Our Case Number: ACP-323606-25

Re: Proposed construction of 67 no. housing units
on a site at Tyrells Land, situated along Stradbally Road, Portlaoise, Co Laois

Ár dTag | Our Ref.
TII25-133148

RE: Proposed construction of 67 no. housing units at Tyrells Land, situated along Stradbally Road, Portlaoise, Co Laois

Figure 5.5: Proposed Stradbally Road/ Internal Access Road junction Layout (Source: Van Dijk Architects)

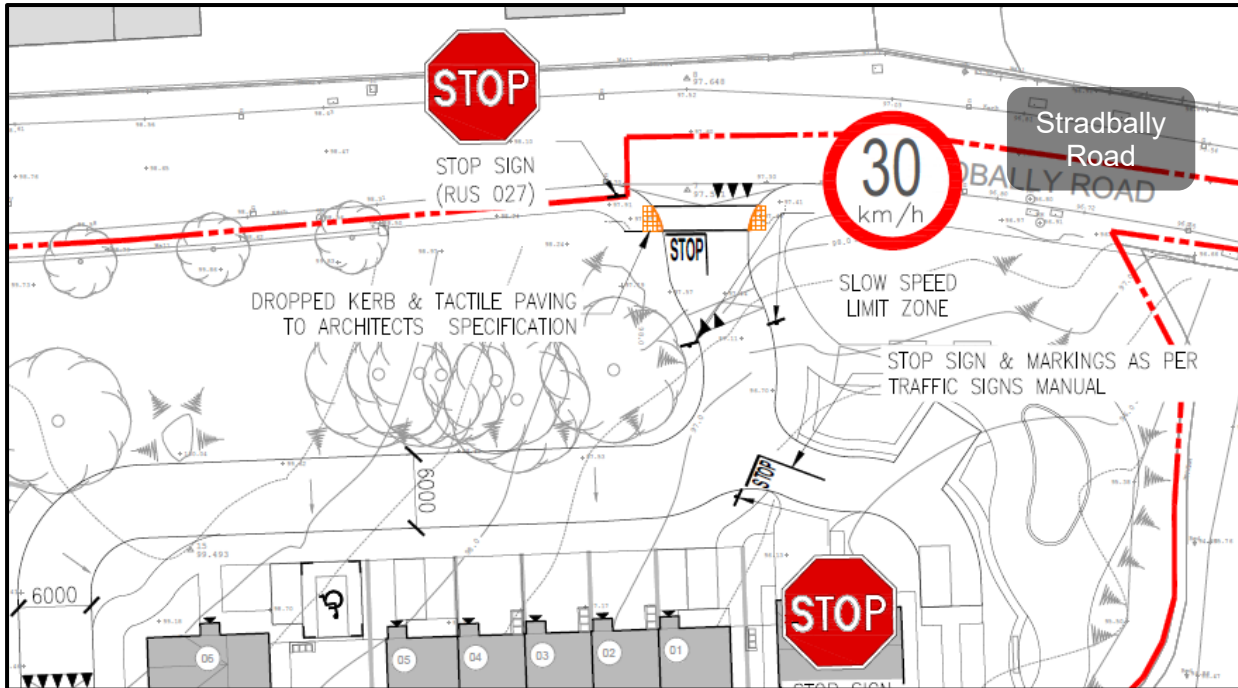
- The response to submissions document identified that a Design Report "...*may be required for the new junction*" offering that the requirement for same can be imposed as condition of planning permission and that "*Any refinements arising from the Design report can be*

incorporated post-permission without altering the site layout". TII advises that the requirement for submission and TII review of a Design Report in accordance with the procedures in TII Publication (Standards) *DN-GEO-03030* is unequivocal having regard to the proposed new junction with the N80, part of the national roads network.

In addition, the response to submissions document commitment offers at post development consent stage that the proposed junction design "*Will be supported by a technical note confirming compliance with TII standards*". Confirmation of compliance with "*TII standards*" as set out in TII Publications is a matter for TII.

Based on the response to submissions document and TII's own records, no Design Report has been submitted to TII in accordance with the requirements of TII Publication (Standards) *DN-GEO-03030*.
